TfNSW Reference: SYD12/00072/53

Client Reference: SSD-7628-MOD-3

**NEW REQUEST FOR ADVICE - MOD 3 - SUBDIVISION PARTIAL DEVELOPMENT
CONSENT MODIFICATION (SSD-7628-MOD-3)**

Reference is made to the Department of Planning, Industry and Environment (the Department) request, dated 6 July 2020, to review the proposed SSD-7628 Modification 3 (the Modification) which was referred to Transport for NSW (TfNSW) for comment.

Figure 5 Proposed Modification – Additional Proposed Lots (shown in red)

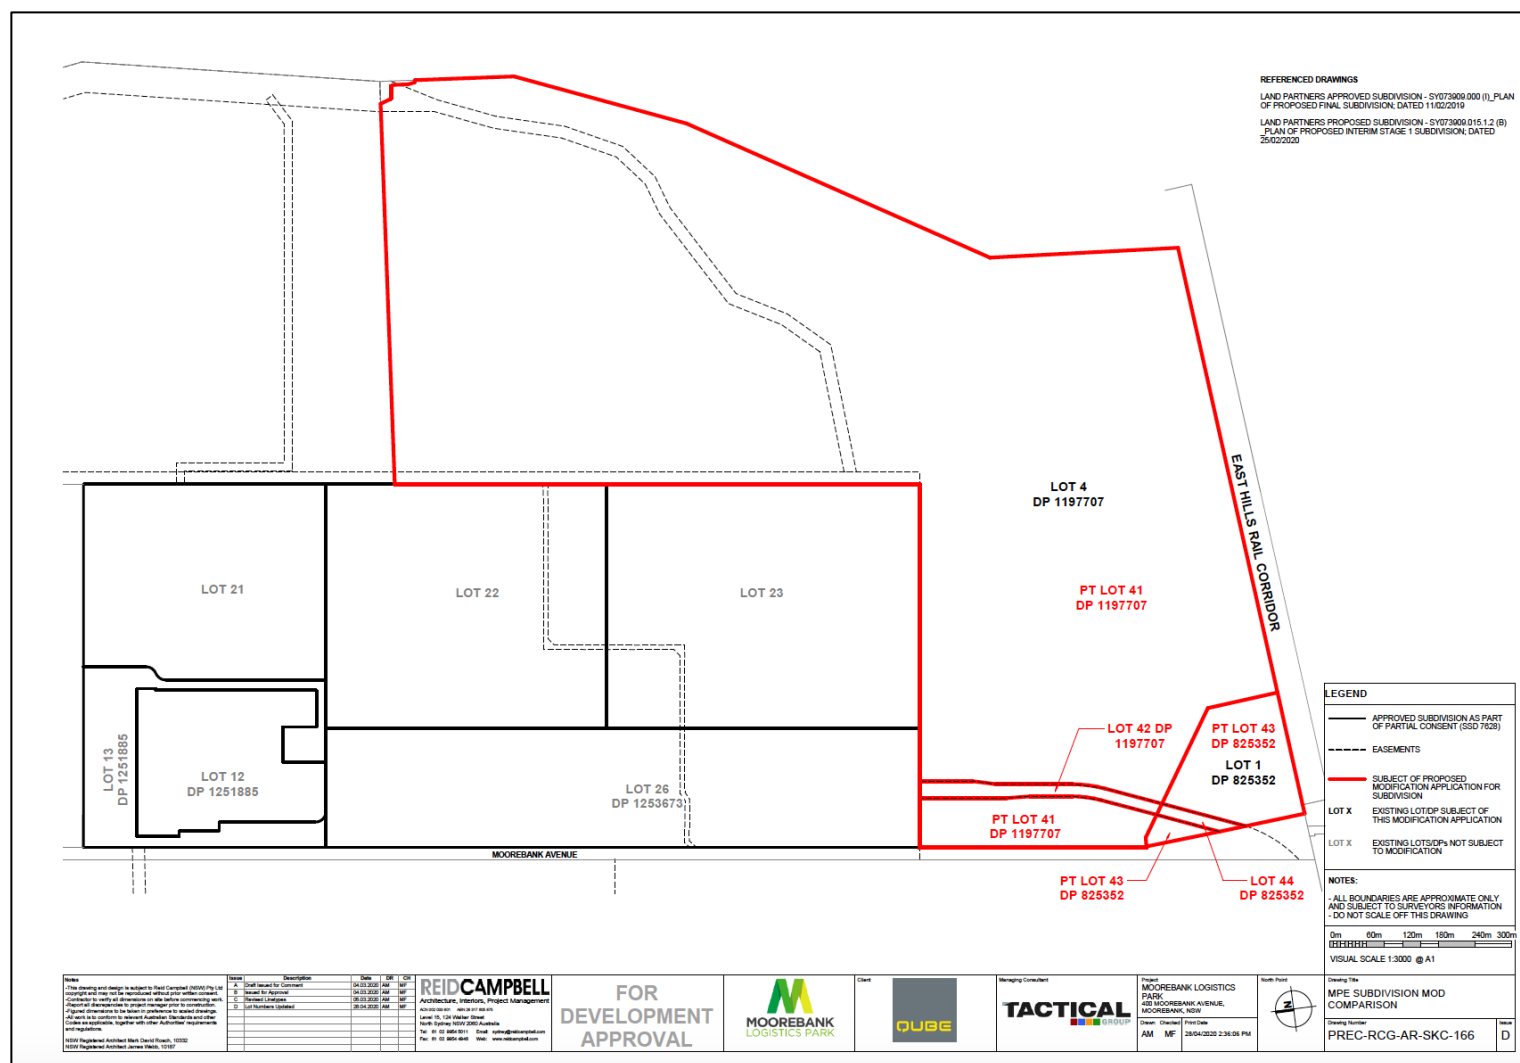
1. TfNSW is concerned that the subdivision of Lot 1 DP 825352 and Lot 4 DP1197707 will complicate delivery of the agreed developer contributions set out in the Voluntary Planning Agreement between TfNSW (formerly Roads and Maritime Services) and the Proponent, by creating more lots and lot owners.

It is noted that a request for Secretary's Environmental Assessment Requirements for the Moorebank Avenue Realignment proposal has been lodged by the Proponent to the Department. However, no information was provided regarding the potential impact of the proposed Modification on the Moorebank Avenue Realignment proposal.

The Department is requested to seek further information from the Proponent as to how the potential impacts of the proposed Modification on the Moorebank Avenue Realignment proposal have been assessed.
